The Member Secretary,
Chennai Metropolitan
Development Authority,
No.1, Gandhi Irwin Road,
CHENNAI -600 008

Letter No. A1/27404/2001

Sub: CMDA - planning permission - Construction of residential building at Plot No.6, in S.No. 536/2 of Pallikaranai village - Development charges and other charges to be remitted - Reg.

TERRACE PLAN

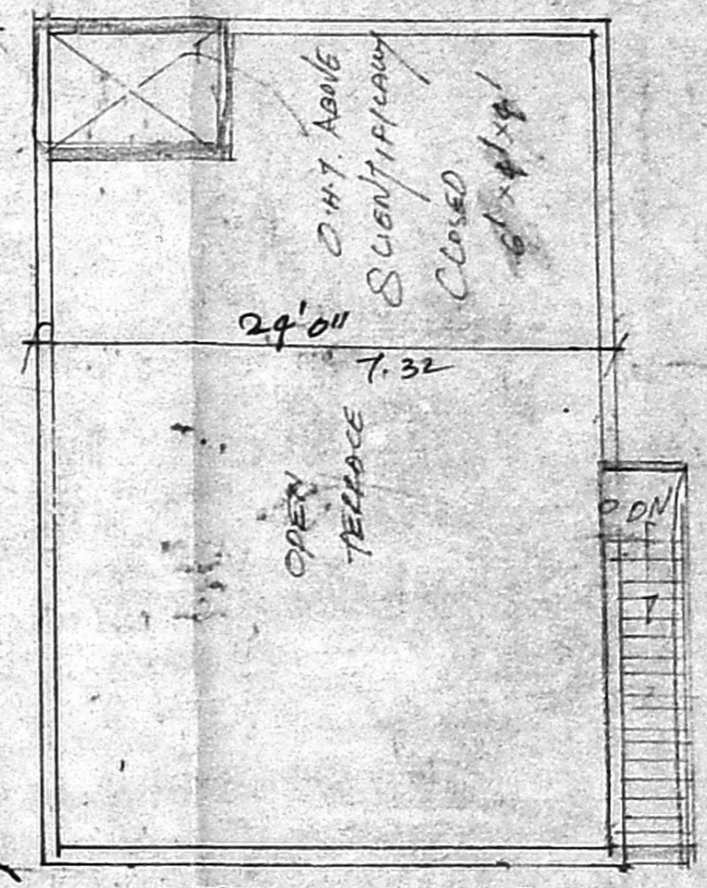
b) 5 copies of Revised plan without ink correction and showing the terrace floor plan.
